**Ref 2022/1201**

Description: Erection of three storey building containing 6no studio apartments  
(Outline seeking approval over layout, scale, appearance and means of access)  
(Amended Address)

Site Address: Land adjacent 1-4 Springfield Street, Barnsley, S70 6HH.

STREET SCENE
SCALE 1:100

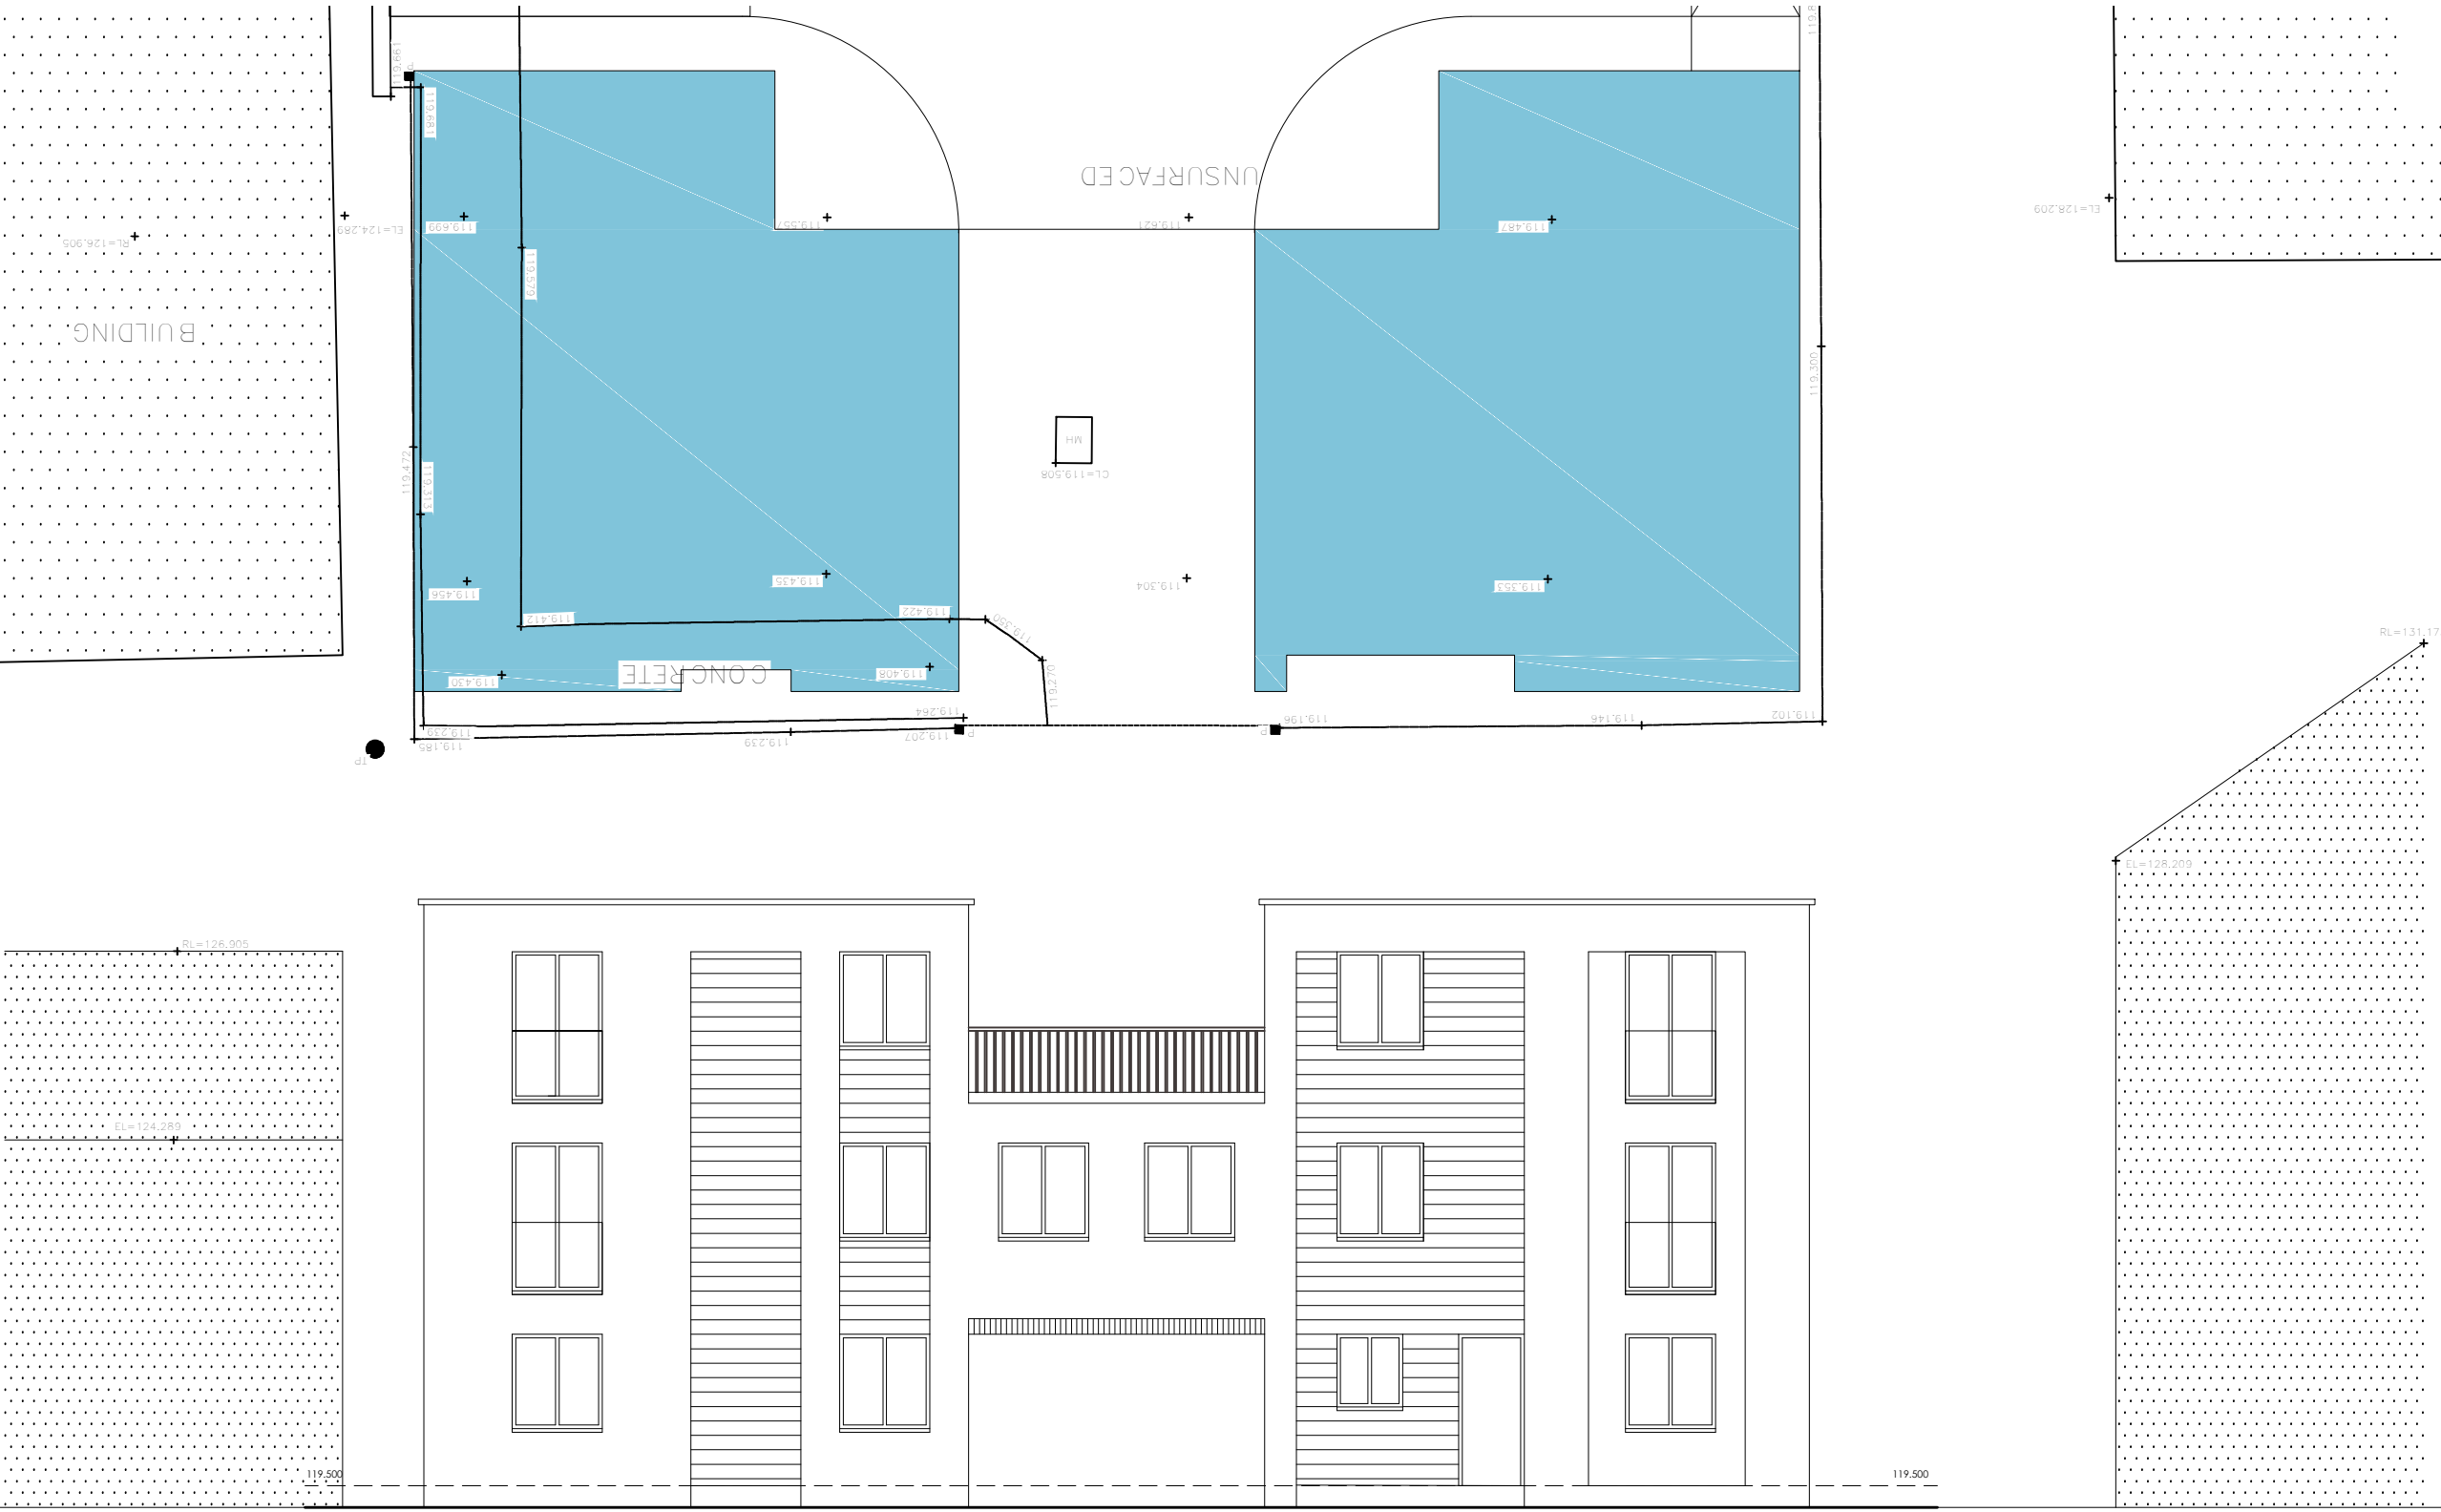
The immediately adjacent buildings also have breathing space around them with gaps to neighbouring buildings. The proposed building would be situated immediately adjacent to the existing flats and also close to the rear elevations of the properties fronting Springfield Place. This would result in this section of Springfield Street appearing very cramped and dense, contrary to the existing development pattern and rhythm of the street, again contrary to the SPD and Local Plan Policy D1. The plans also fail to demonstrate any areas for soft landscaping within the site as it is fully occupied by the building and areas of hardstanding required for parking.
